**DERRYGREENAGH POWER  
PLANT**

**RESPONSE TO HSA  
REQUEST FOR FURTHER  
INFORMATION REFERENCE  
PAR 4351**

237501.0530RR03

4<sup>th</sup> November 2024

DRAWING No.: **S7060-8050-0055-1** Sheet 1 of 8 REVISION: **R1.0**

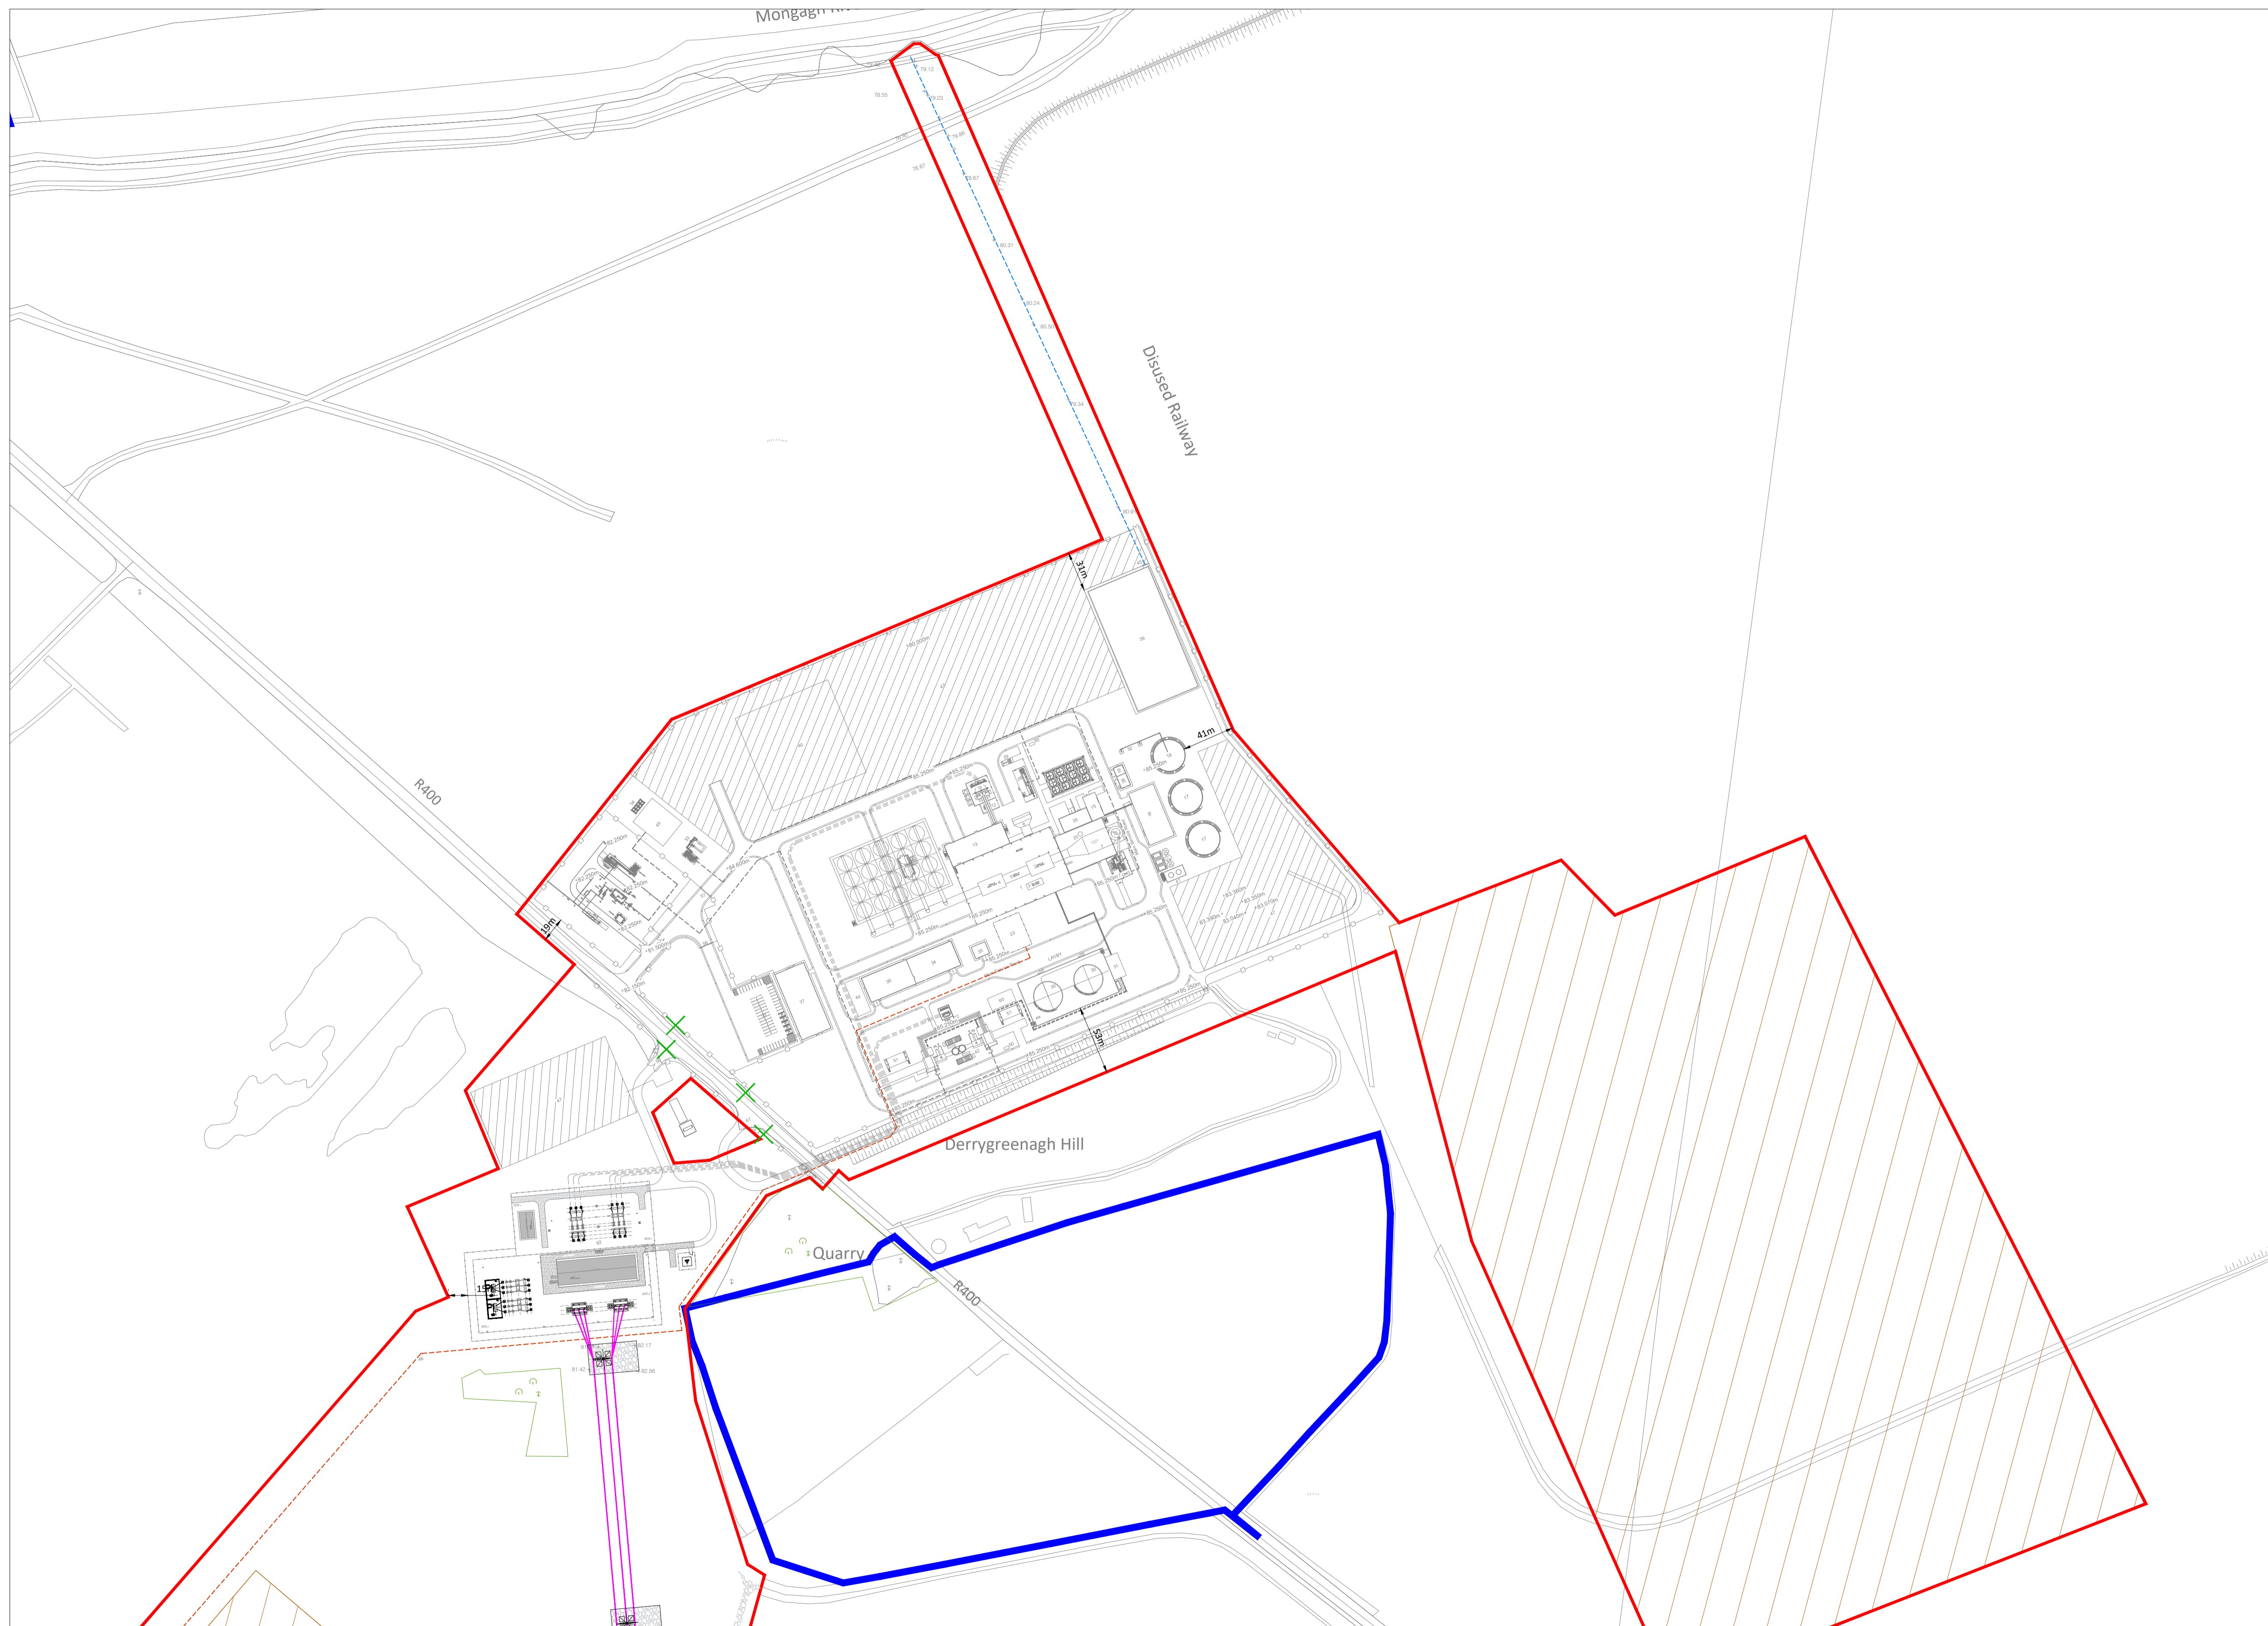
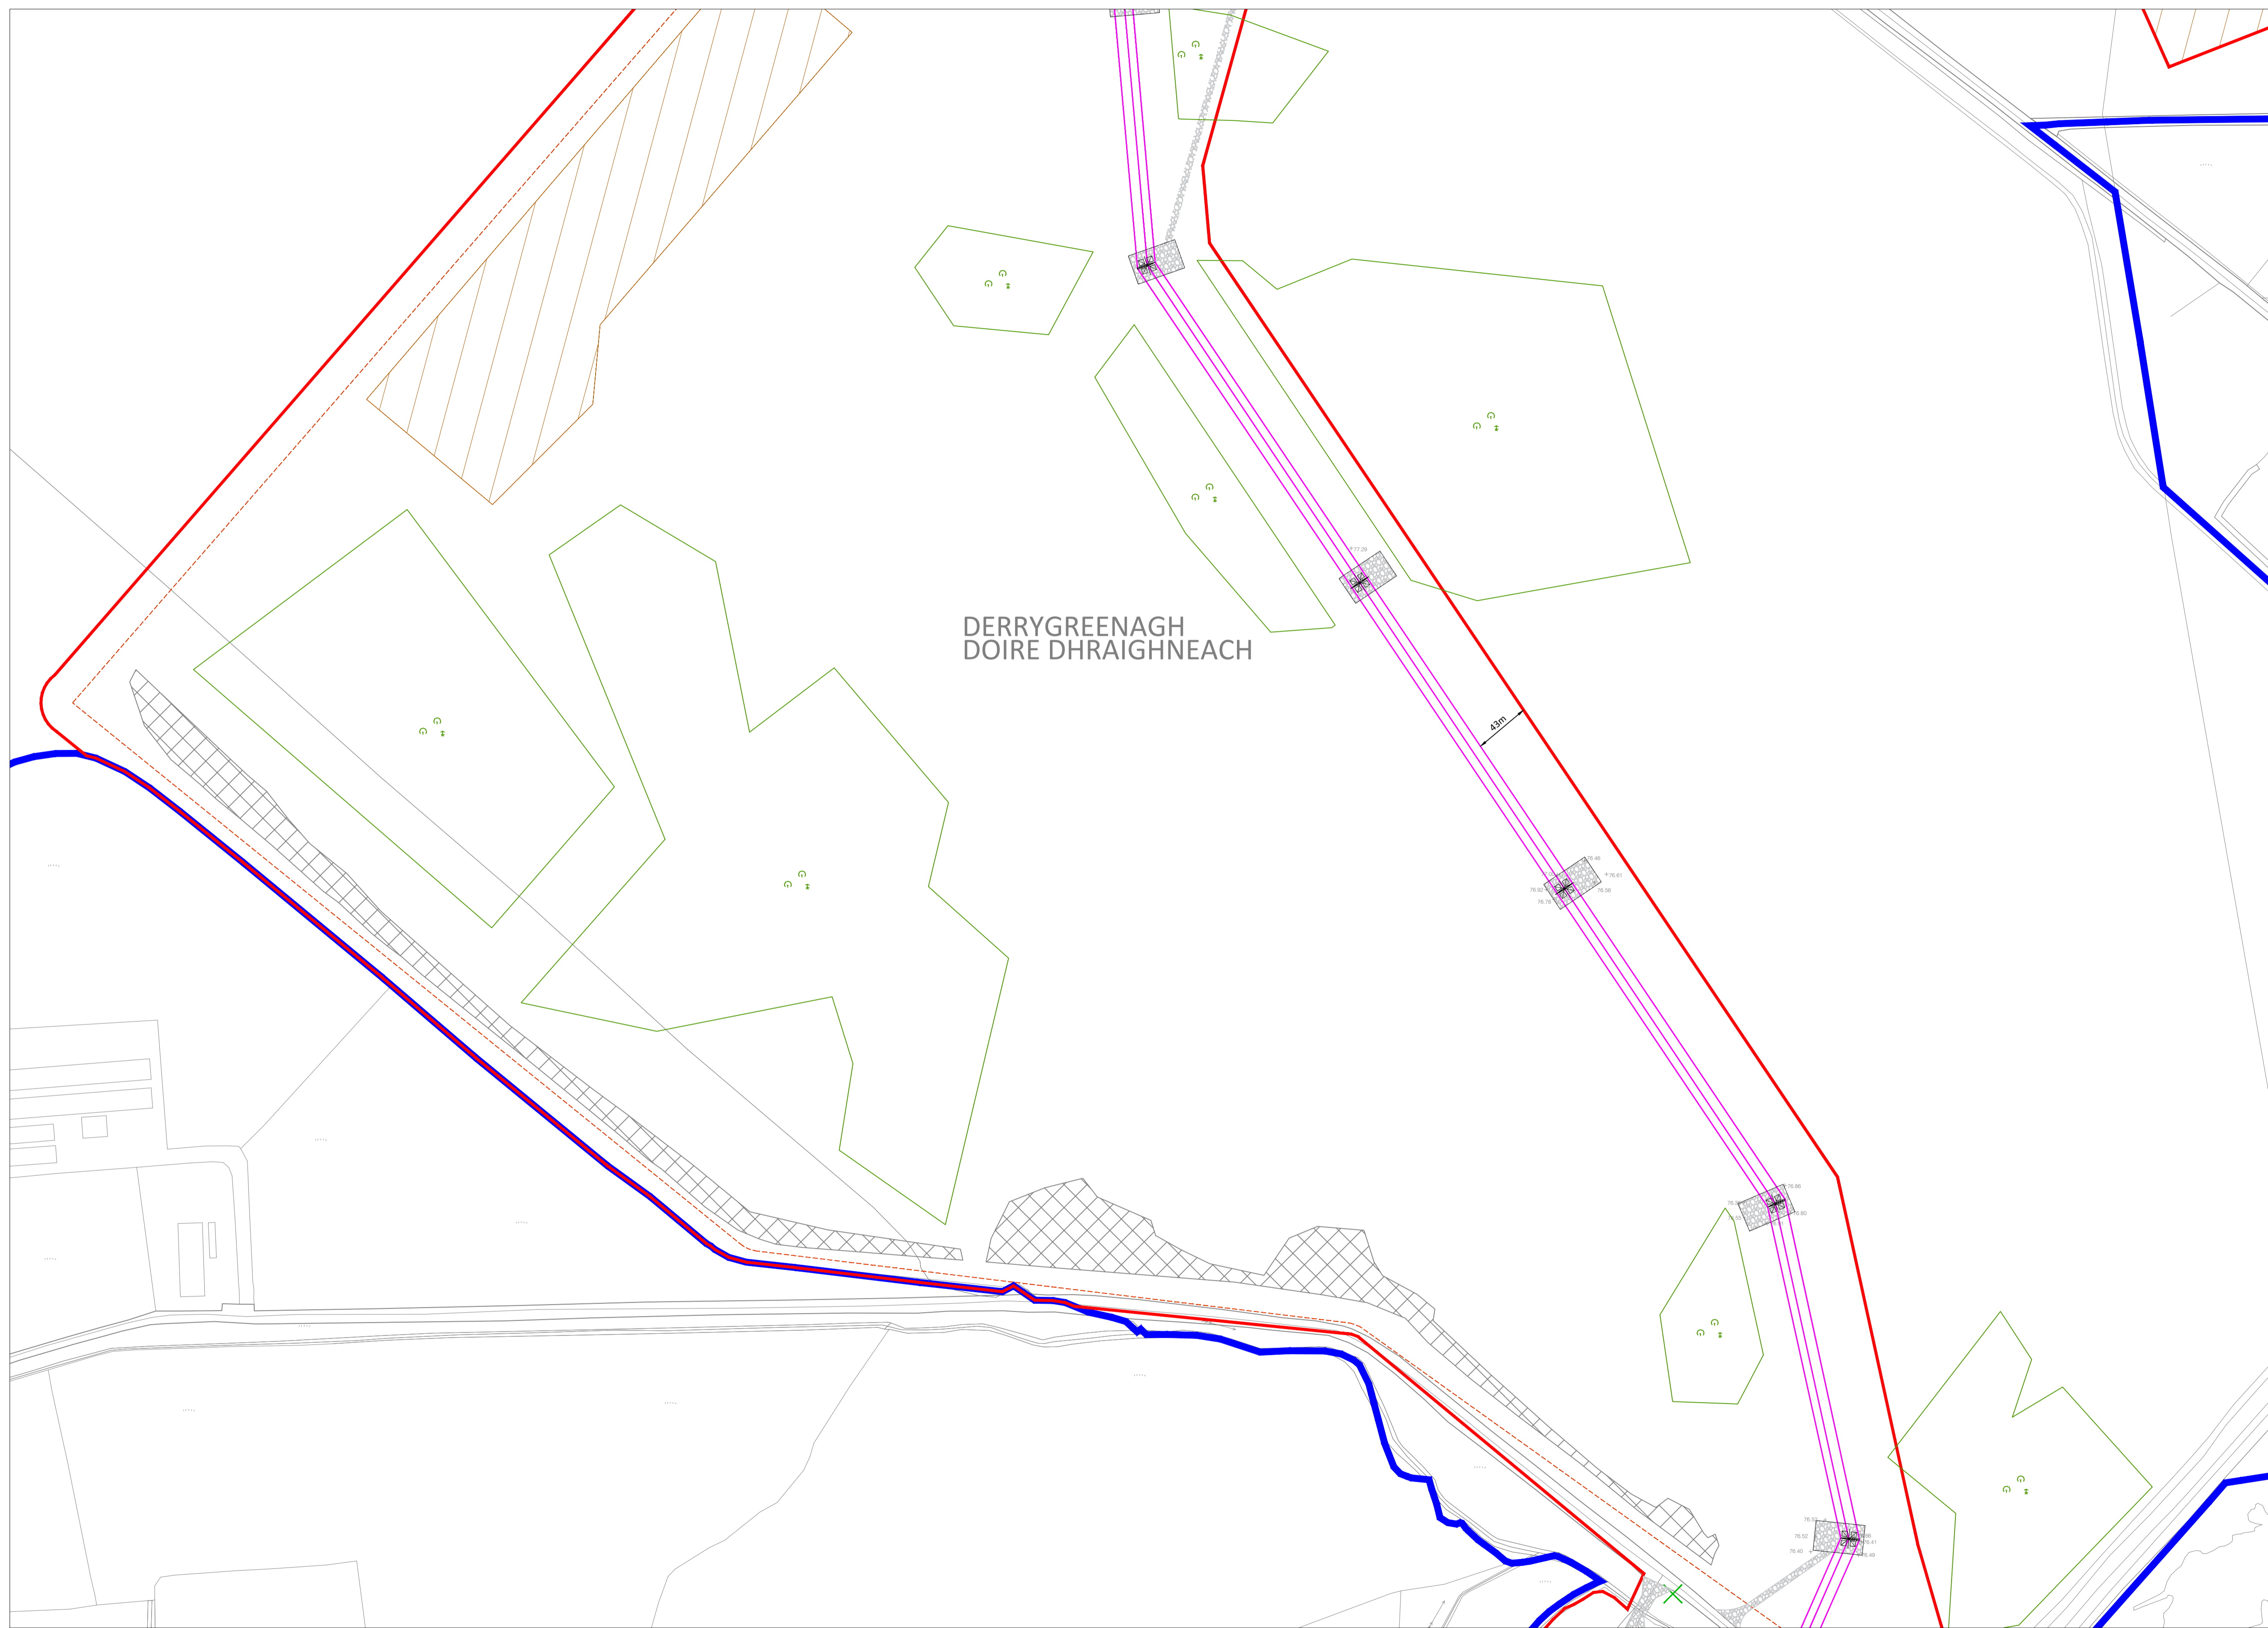
*Fig 1 site boundary [red line indicating proposed planning application site boundary] is different to fig. 2 COMAH boundary. Also, the site boundary indicated in Appendix 16.3 of EIA is different to that on the proposed development site location map sheet 1 of 8. Ref. S7060-8050-0040-1Rev 1.0. All operations and activities associated with the COMAH site must be incorporated within the COMAH site boundary. Further clarification on this boundary is required.*

*'The site boundary shown on 'Figure 1', of the LUP report shows the planning application boundary. 'Figure 2' of the LUP report shows the COMAH boundary. The planning application boundary does not have to be the same as the proposed COMAH boundary. The COMAH boundary is the boundary of the proposed power plant area that will be the 'Establishment' under which the COMAH regulations apply. The blue line around the layout shows the proposed COMAH boundary and it encloses the power plant area.'*

Figure 1 of the LUP report shows the proposed planning application boundary which includes:

- CCGT Unit, including CCGT Turbine Hall and buildings, Heat Recovery Steam Generator (HRSG);
- OCGT Unit and emissions stack;
- Secondary Fuel Storage and Unloading Facility;
- Gas Connection Corridor AGI Compound;
- Associated buildings and infrastructure and subsidiary items of plant/ equipment;
- Electricity Grid Connection, including 220kV Substation, 220kV Overhead Line, 220kV Line-Cable Interface Compound, 220kV Underground Connection and 400kV 'Loop-in' Substation at entry point to the 400kV transmission network.

The high voltage Electricity Grid Connection and infrastructure will be operated by EirGrid the transmission system operator following installation and owned by the asset owner ESB. The Electricity Grid Connection and infrastructure does not fall under the COMAH regulations and will not form part of the COMAH boundary.

The proposed COMAH boundary relates to the main thermal power plant area east of the R400 road, which includes Combined Cycle Gas Turbine (CCGT) and Open Cycle Gas Turbine (OCGT) plant, a gas Above Ground Installation (AGI), water abstraction and water treatment infrastructure, respective surface and process water discharge connection routes.

The proposed COMAH boundary includes all activities associated with COMAH activities.
